**GLENVALE PARK – Phase 1 Local Centre
Non-material amendment application in relation to reserved
matters approval NW/22/00170/REM**

I write in relation to reserved matters approval NW/22/00170/REM for the Glenvale Park Phase 1 Site R4 Local Centre, and the proposed non-material amendment (NMA) application which seeks to update a number of plans associated with this approval.

SCHEDULE 1

NORTH WELLINGBOROUGH LOCAL CENTRE
PGR CONSTRUCTION
PROPOSED ELEVATIONS - RETAIL + RESIDENTIAL

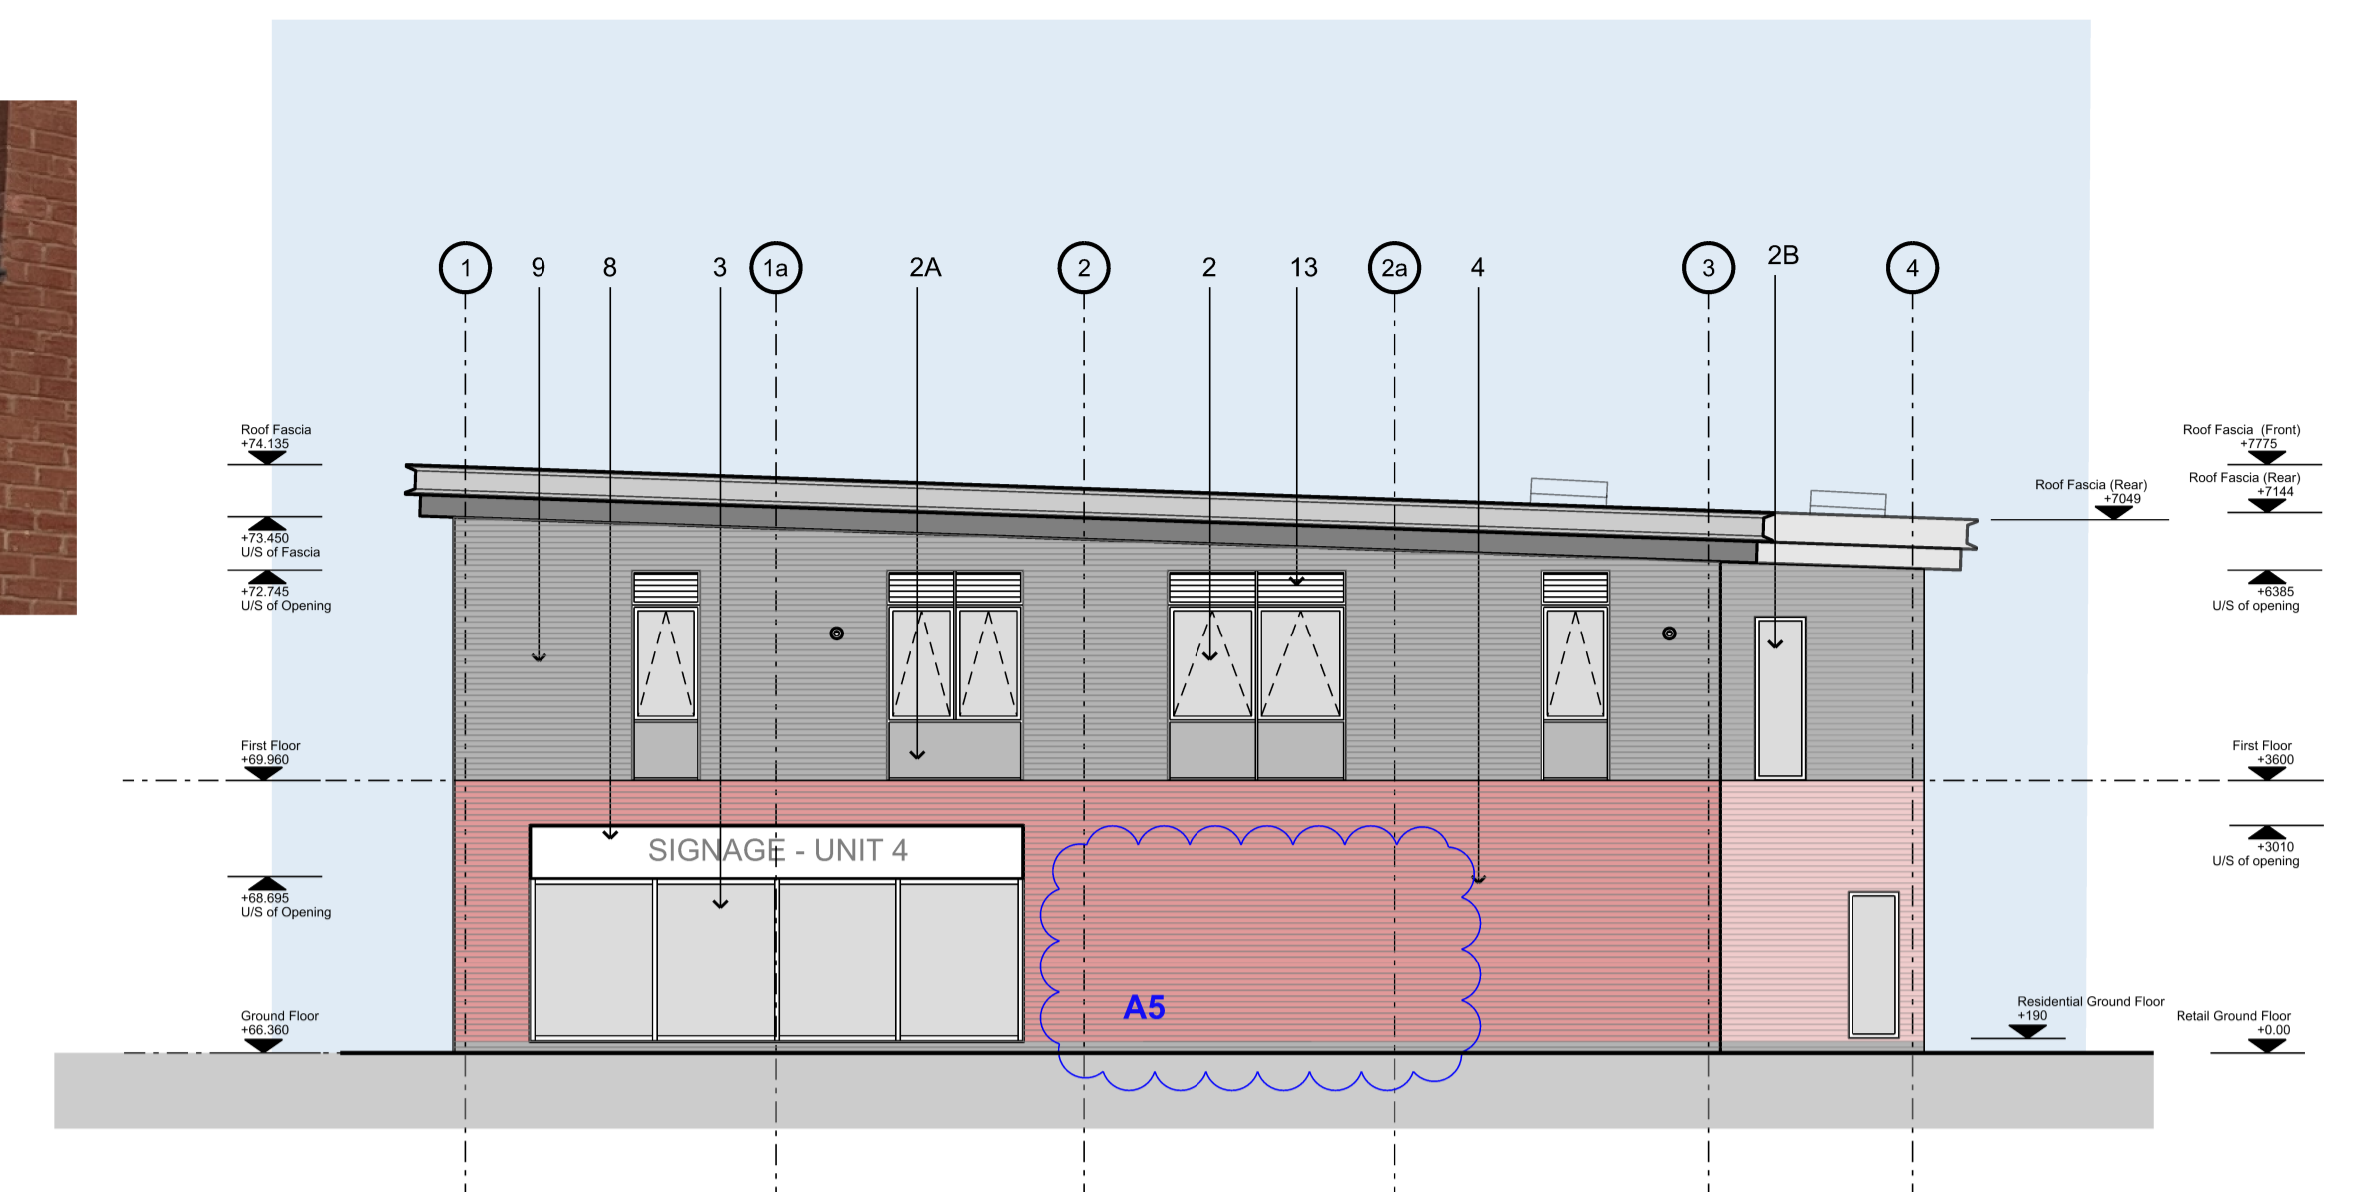
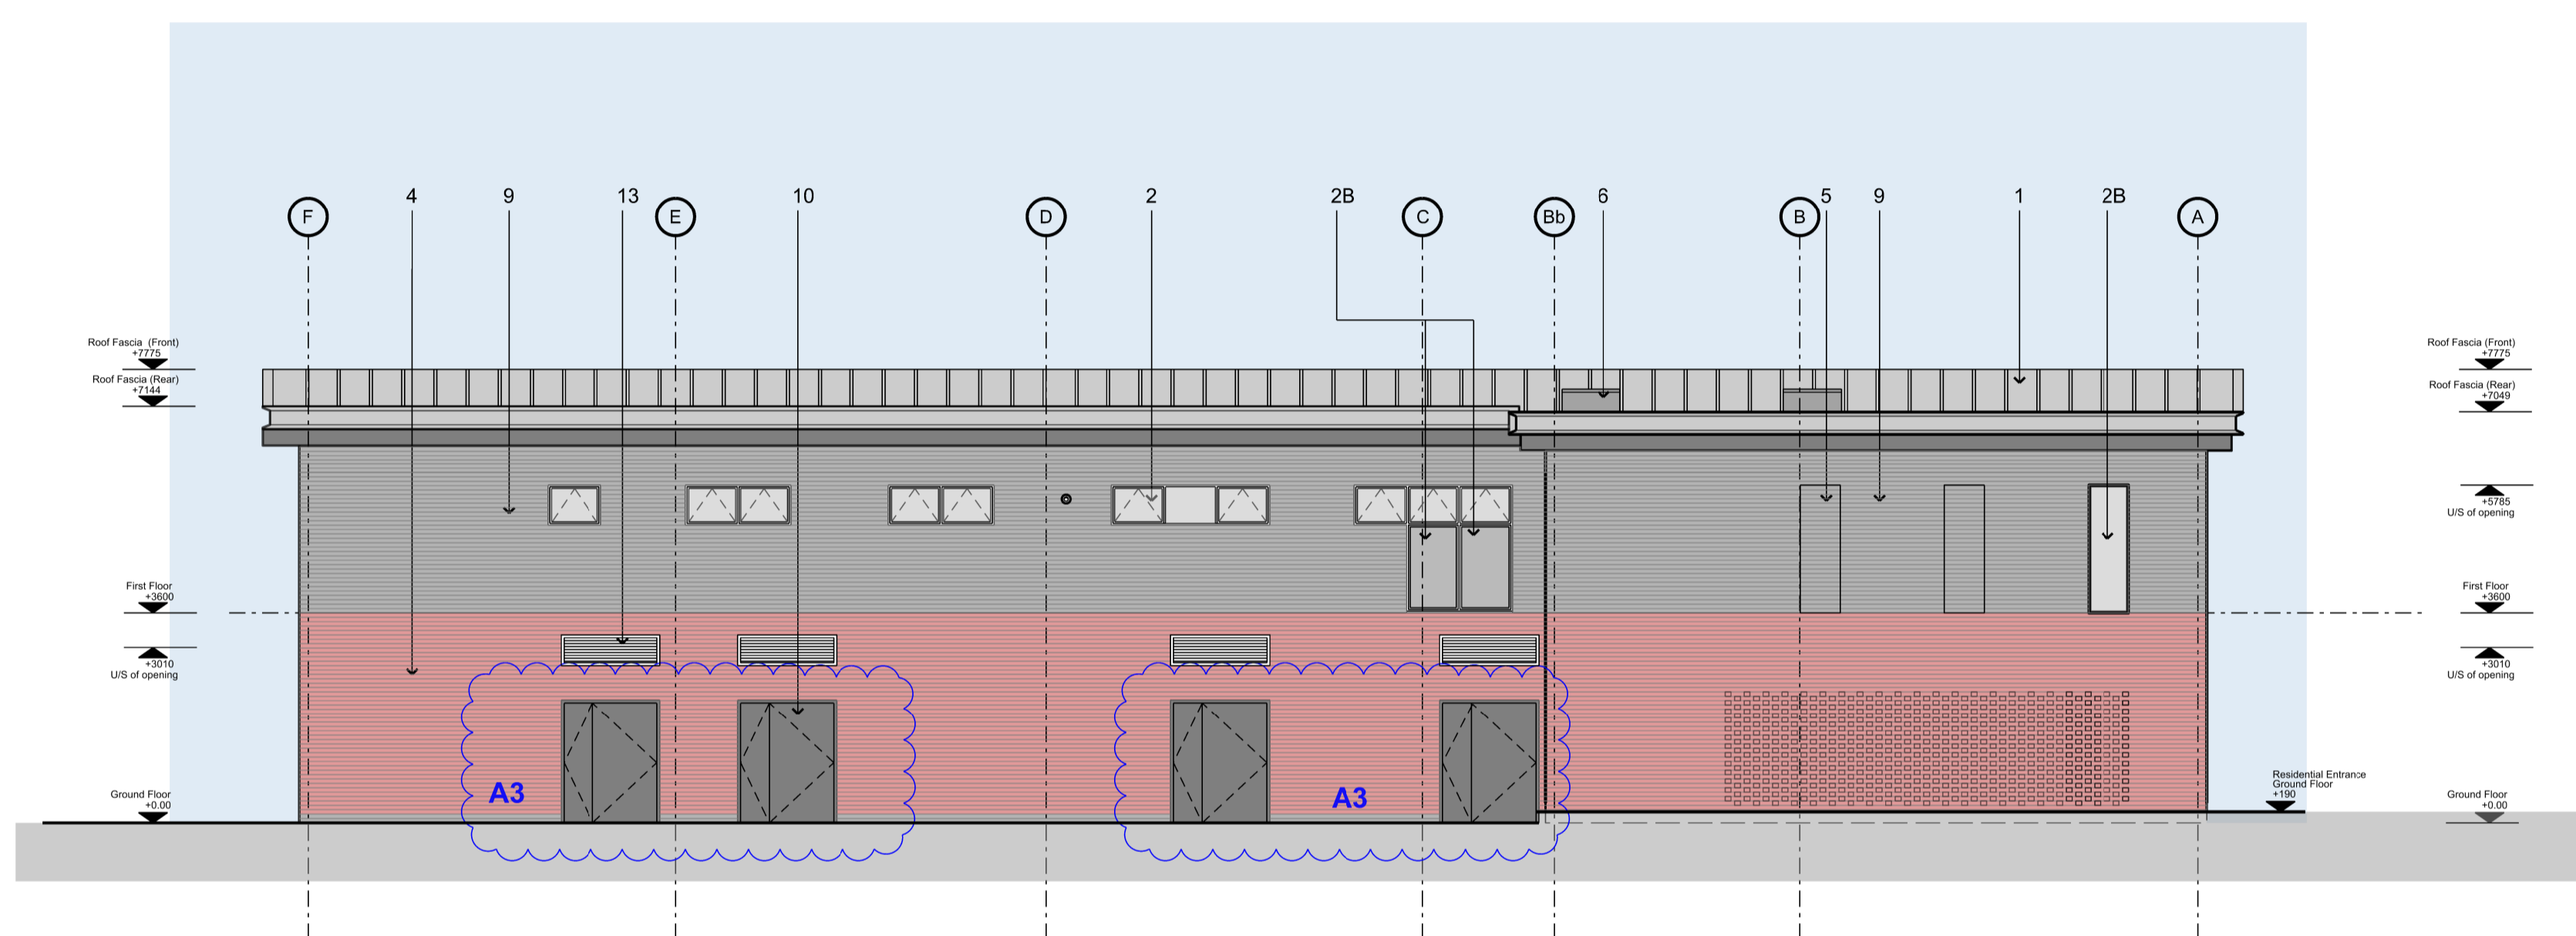
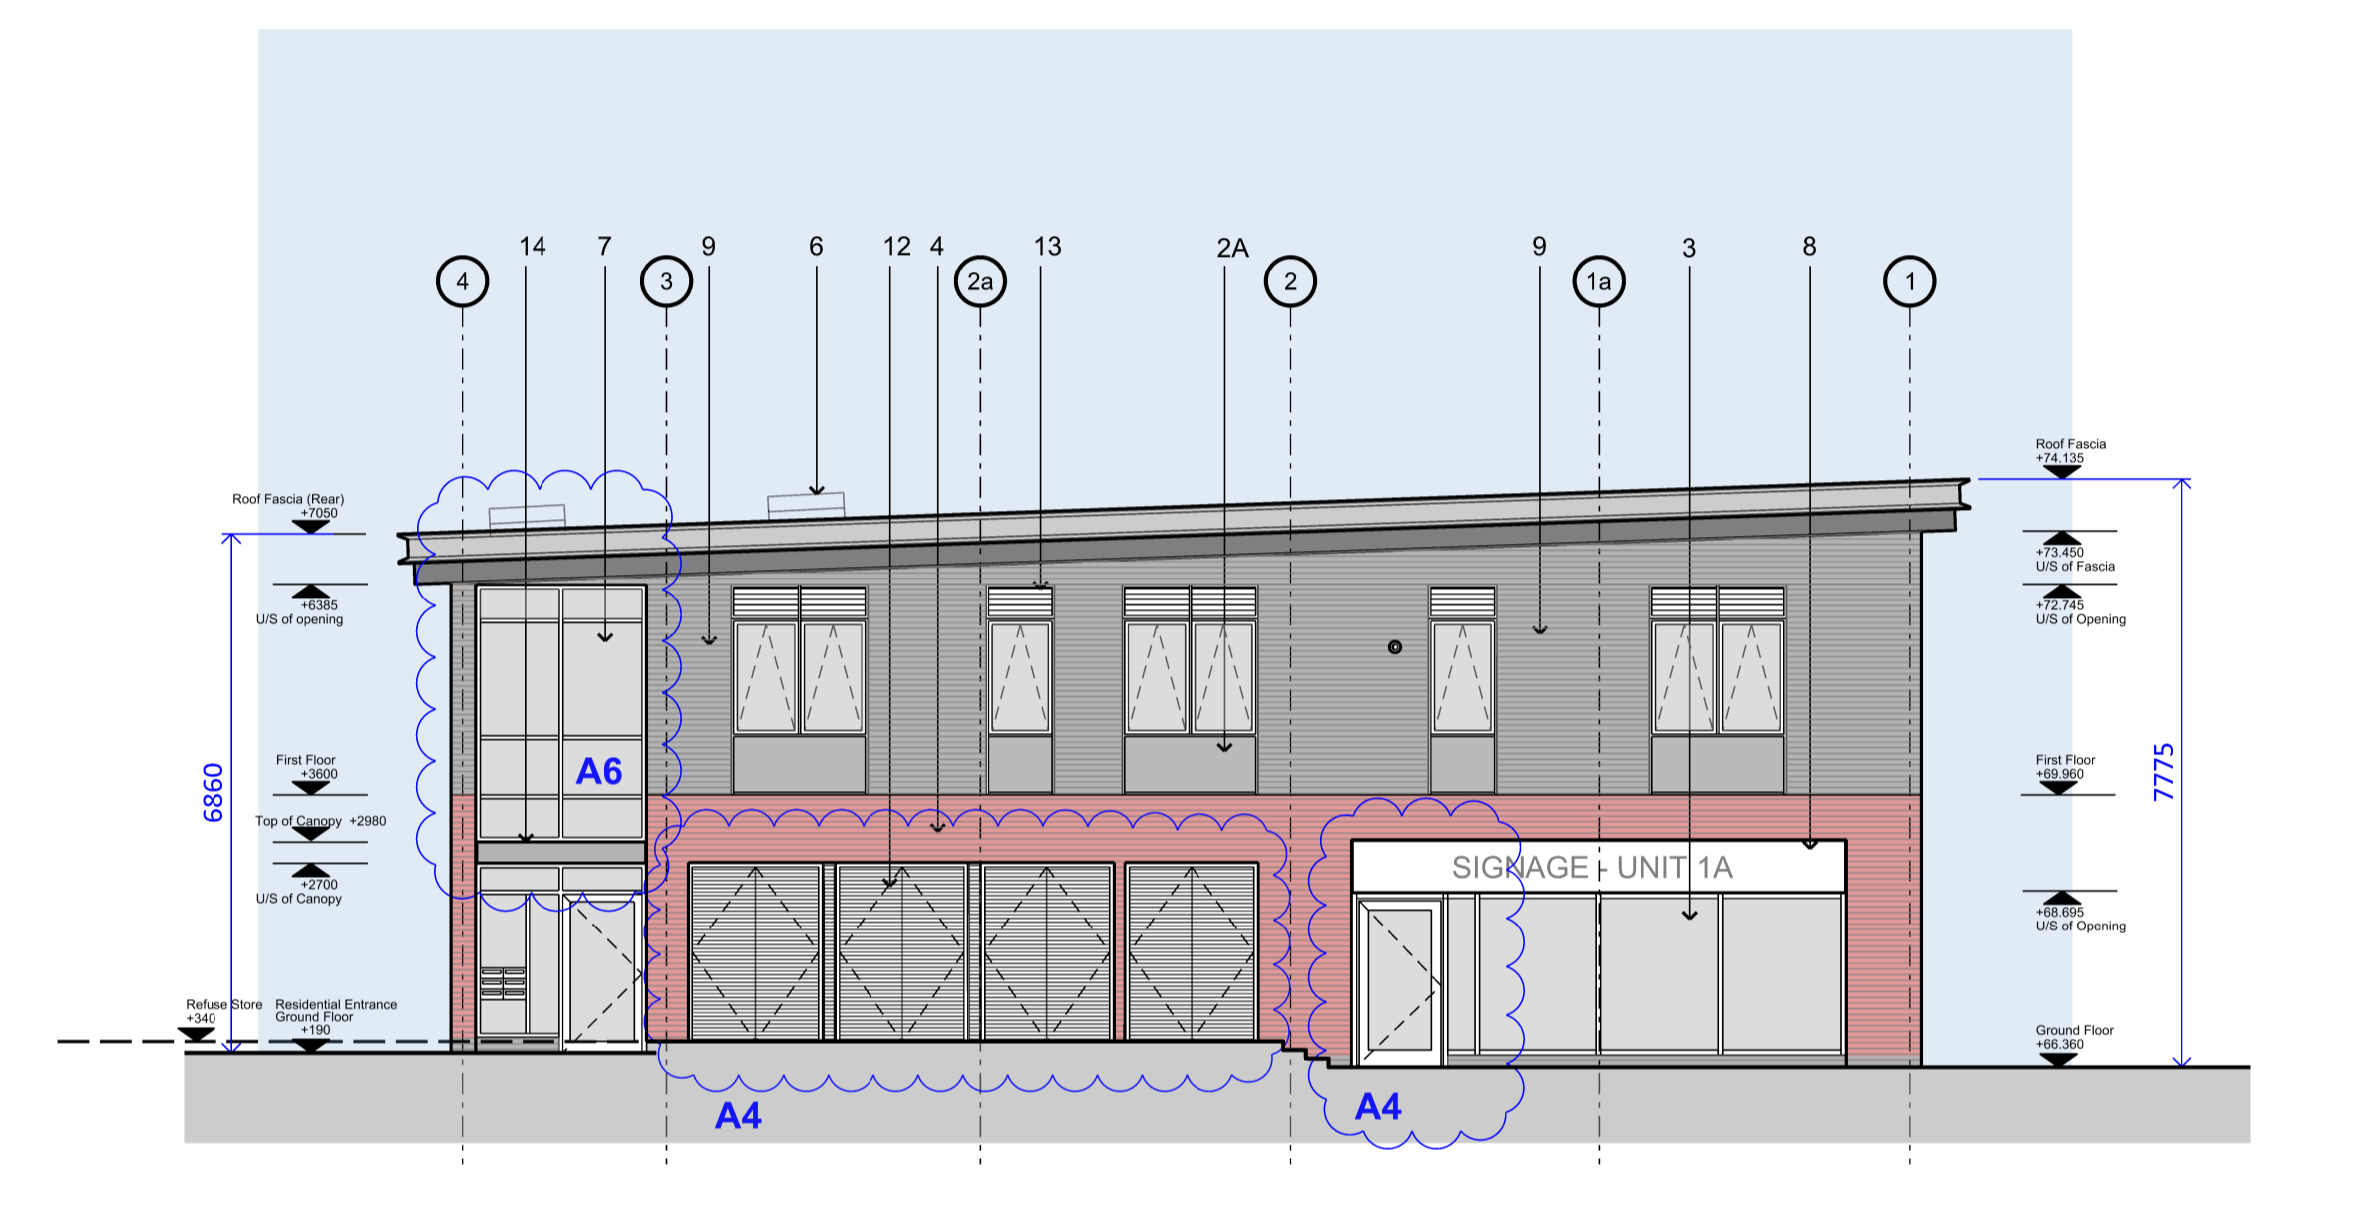
RETAIL UNITS & RESIDENTIAL APARTMENTS APPROVED UNDER REF. NW/22/00170/REM DRAWING NO. 1033-005-P8		
REF.	CHANGE FROM APPROVED	REASON
	DRAWING NO. 1495-403-P5 PROPOSED ELEVATIONS	
A1	ALL ELEVATIONS: STACK BONDED BRICK PANELS REMOVED STRETCHER BOND FACING BRICK PANELS IN LIEU OF STACK BOND BRICK PATTERN	BUILDABILITY RATIONALISATION OF BRICK PANELS & DETAILING. MINIMAL VISUAL IMPACT ON ELEVATIONS AT FIRST FLOOR LEVEL.
A2	UNIT 2: ENTRANCE DOOR RE-LOCATED CENTRAL TO SHOPFRONT	TENANT REQUIREMENT
A3	NORTH ELEVATION: REAR EXIT DOORS TO UNITS CHANGE FROM SINGLE DOOR TO DOUBLE LEAF DOOR	BUILDING CONTROL REQUIREMENT
A4	WEST ELEVATION: UNIT 1A EXIT DOOR IN SHOPFRONT & BIN STORE DOORS IN LIEU OF ONE SHOPFRONT.	FIRE EXIT FROM UNIT - BUILDING CONTROL REQUIREMENT. BIN LAYOUT & BIN DOORS REQUIRED DUE TO EXTERNAL LEVELS DIFFERENCE.
A5	EAST ELEVATION: ONE SHOPFRONT REMOVED	TENANT SECURITY & OUTLOOK DUE TO PROXIMITY OF ADJACENT RESIDENTIAL DWELLINGS

A6	WEST ELEVATION: INCREASED TO TWO-STOREY OVER RESIDENTIAL ENTRANCE. PREVIOUSLY SINGLE STOREY WITH FLAT ROOF & 1ST FLOOR SET BACK.	IMPROVED INTERNAL USER ACCESS FOR SERVICES & BIKES
